**Your Ref: 2023/93082**  
**Our Ref: Z005388**

**10th November 2023**

**Land Adjacent 60 Northgate, Cleckheaton - Discharge of conditions 4 (foul and surface water drainage details), 8 (car park drainage), 22 (no building over sewer) and 25 (surface water disposal/rate of discharge) of previous permission 2022/91730 - Demolition of former dairy/snooker centre/storage and erection of 9 light industrial units**

Scott Lane, Cleckheaton, BD19 4JY – S116 Sewer Closure V326571

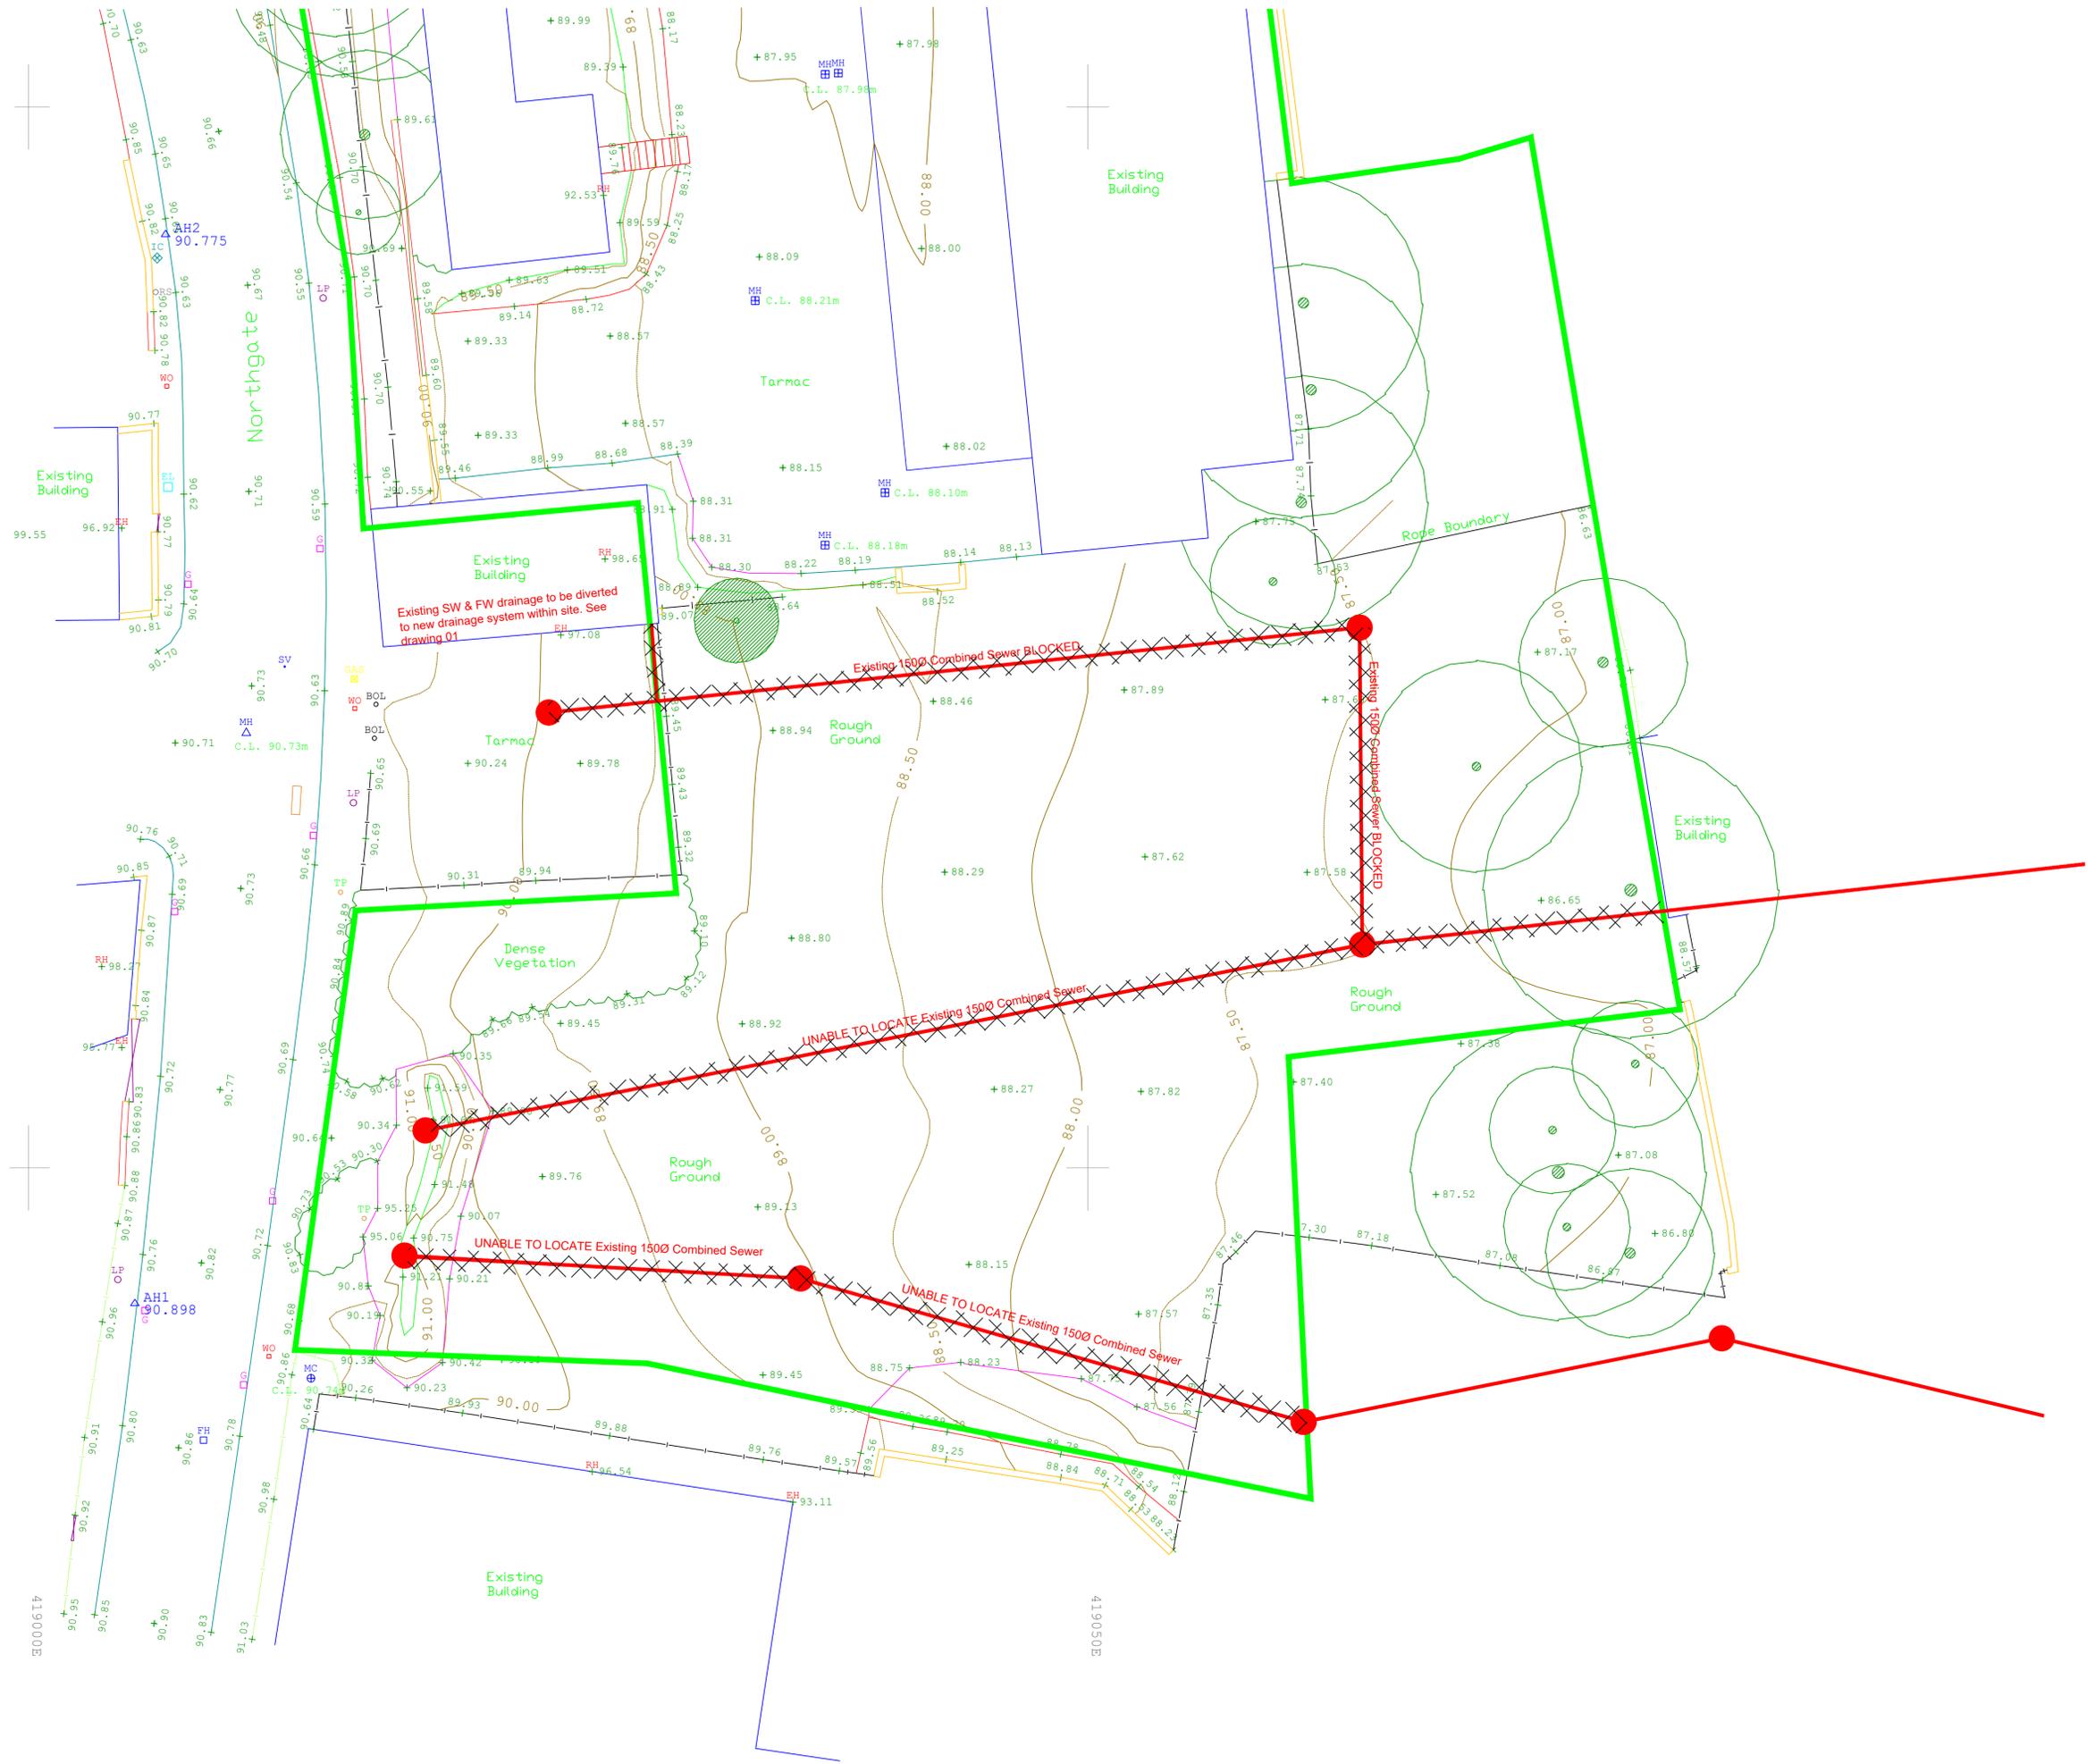
Yorkshire Water objects to discharge of condition 22.

No evidence of a formal agreement under Section 185 or Section 116 of the Water Industry Act 1991 that the diversion or closure has been submitted.
